Appeal Decision

Appeal Ref: APP/T2350/D/22/3299040

Winton, 145 Whalley Road, Wilpshire, Blackburn, BB1 9NE

- The appeal is made under section 78 of the Town and Country Planning Act 1990 against a refusal to grant planning permission.
 - The appeal is made by Mr M Khan against the decision of Ribble Valley Borough Council.
 - The application Ref 3/2021/0944, dated 13 September 2021, was refused by notice dated 24 February 2022.
 - The development proposed is retrospective planning application for the retention of existing outbuilding containers on site used as ancillary leisure space for Winton House.
-

Title: Proposed Containers	Drawn: NME
Client: Mr Khan	Checked:
Date: 06-09-2021	Paper: A3
Drawing No: HAD3341-04	Scale: 1:100
Revision:

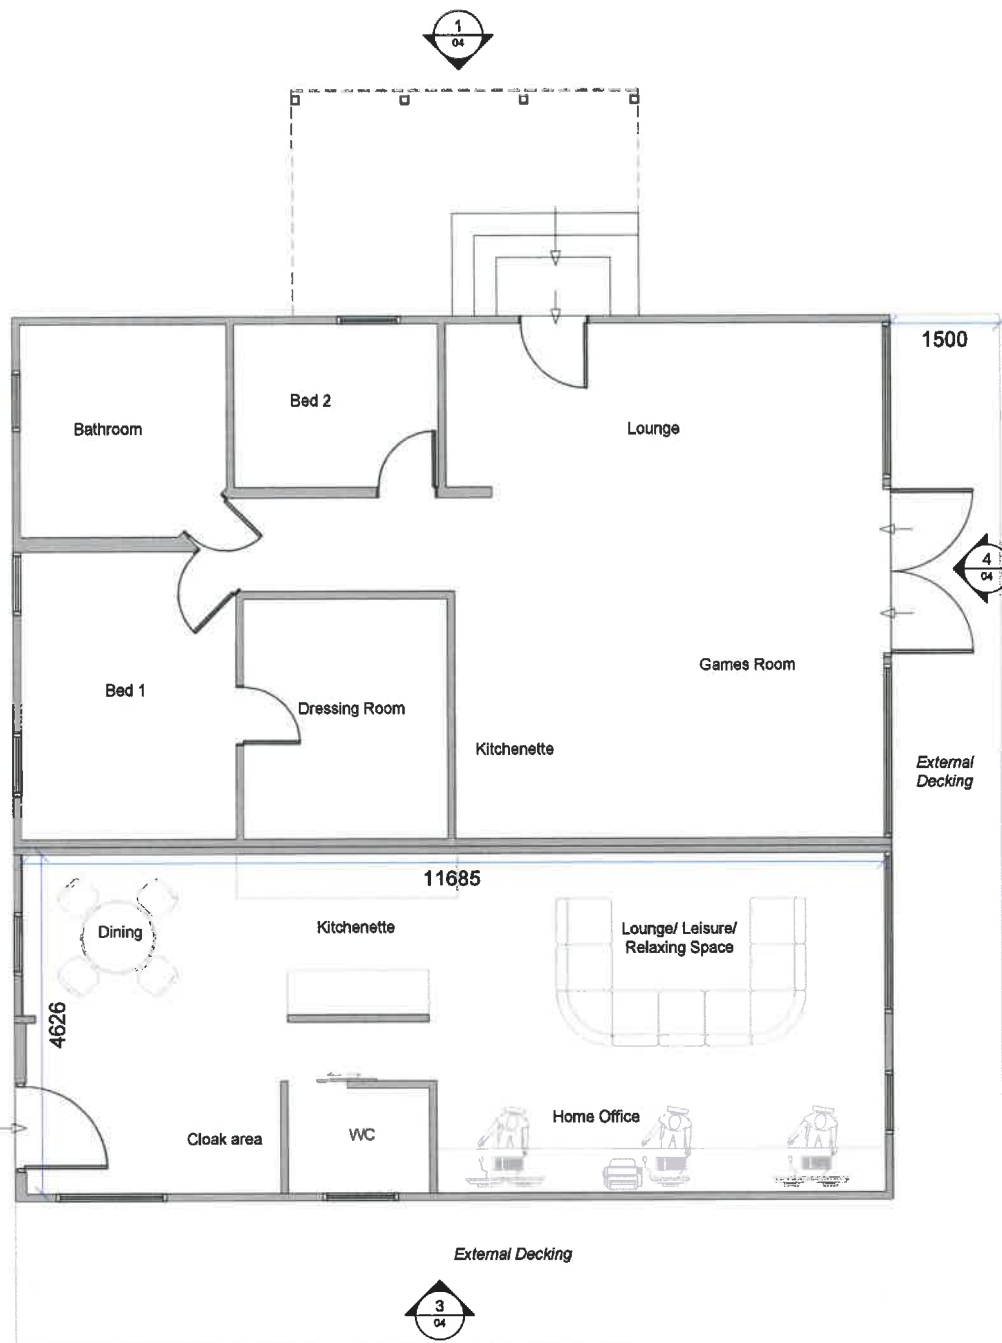
6. The description of the development indicates the proposal would be ancillary leisure space for the appeal property. On the basis of the plans and from what I saw, it includes lounge, kitchen and dining areas, bedrooms and bathroom. While the open plan area could be used for indoor games, the development provides internal living accommodation and it does not meet the exception in paragraph 149 b) appropriate facilities for outdoor sport or recreation.

12. If the appeal was allowed, the storage containers would be finished with a green pitched roof and timber cladding. This would result in a more attractive external finish. Irrespective, by virtue of its large size, design, extensive timber cladding and glazing, the proposal would be a prominent and discordant feature that would be out of keeping and it would not relate well to the surrounding relatively traditional built development. The development is to the rear of the appeal property, screened from the road and footways to the front by dense planting. However, vegetation is not permanent and there would be no guarantee of future screening. Moreover, based on the plans and from what I saw it seems likely that it would be visible from locations elsewhere, including at times of year when vegetation is not in leaf.

16. Notwithstanding the description of development, the evidence suggests the proposal would be used by elderly relatives residing in the main dwelling. However, there is little evidence it would be primarily ancillary accommodation for elderly or dependent relatives. At just under 144sqm of floor space and with facilities for independent living by several persons, the proposal would not be a modest level of accommodation nor, taking into account its size and separation, would it be demonstrably capable of integration into the main dwelling or other ancillary use.

Title: Proposed Site Plan	Drawn: NME
Client: Mr Khan	Checked:
Date: 13-09-2021	Paper: A3
Drawing No: HAD3341-05	Scale: 1:500
Revision:

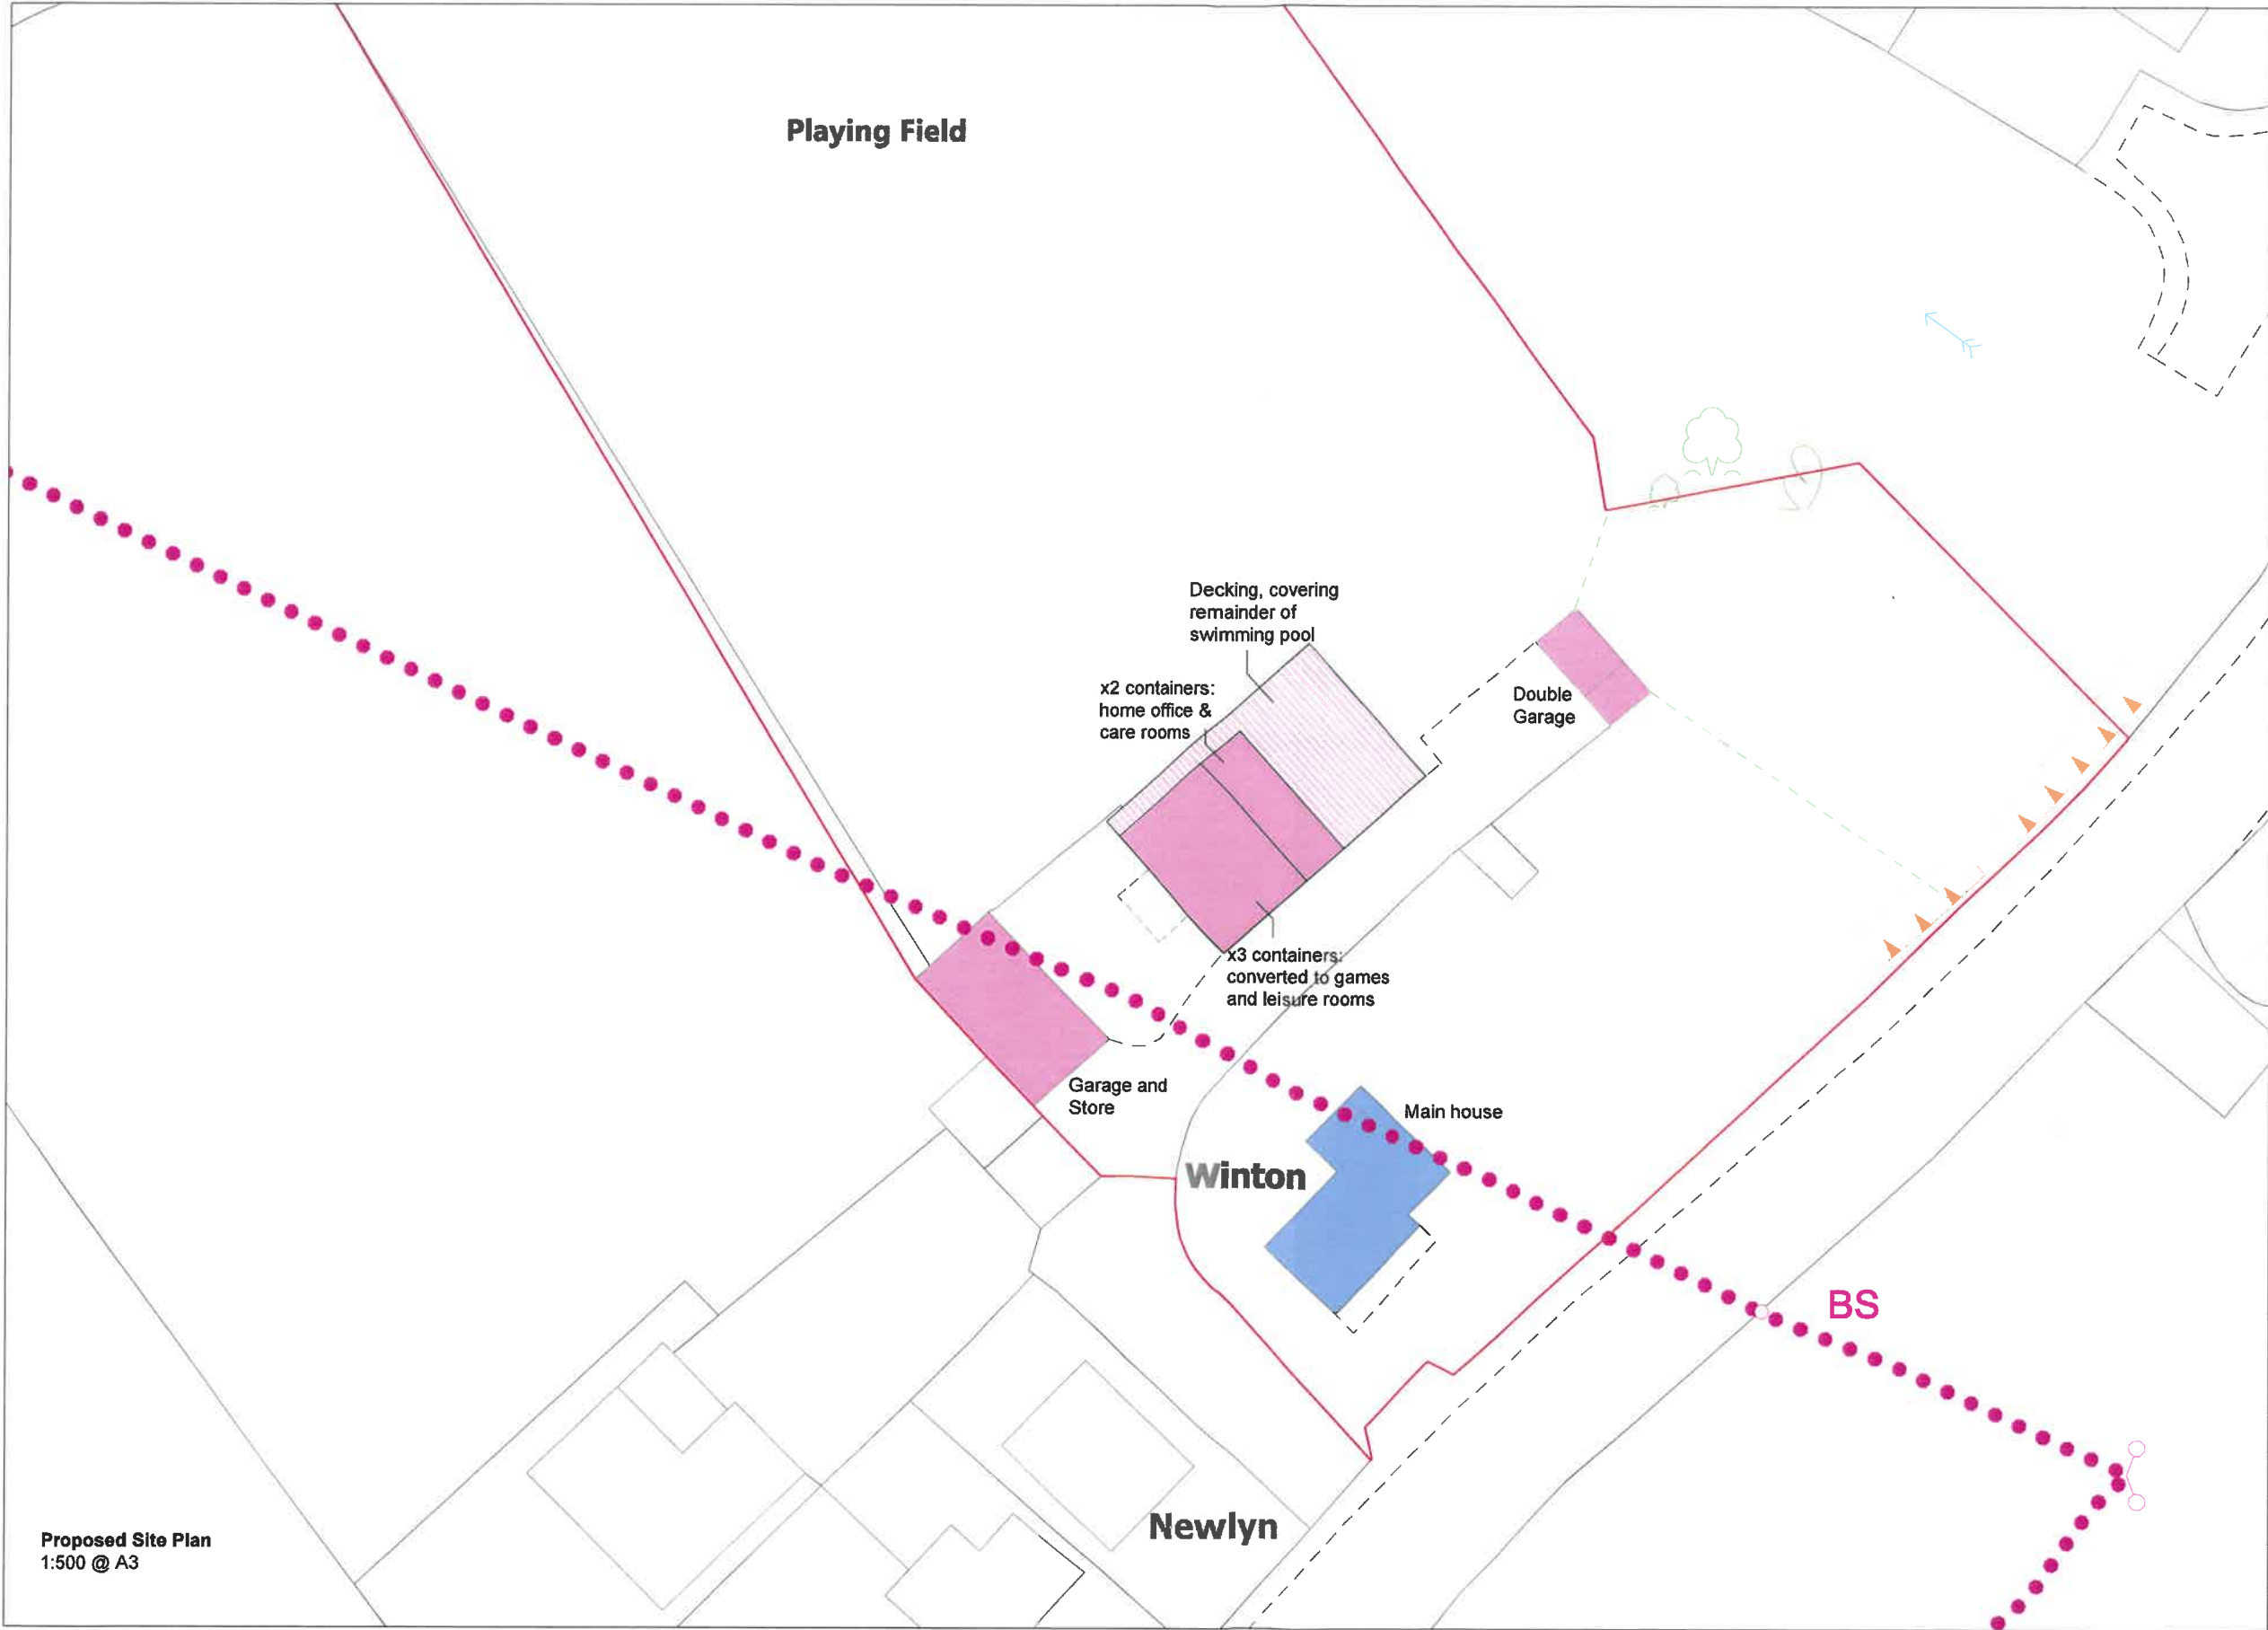
2. The main issues are:
 - i) Whether the proposal would be inappropriate development in the Green Belt having regard to the National Planning Policy Framework (the Framework) and development plan policies;
 - ii) The effect of the proposal on the openness of the Green Belt and visual amenity;
 - iii) Whether the proposal would be an ancillary extension to the dwelling; and
 - iv) If the development is inappropriate, whether the harm by reason of inappropriateness or other harm is clearly outweighed by other considerations so as to amount to the very special circumstances necessary to justify the development.

its siting and scale, the appeal scheme serves to enclose the rear of the host property and it increases the spatial envelope and extent of buildings.
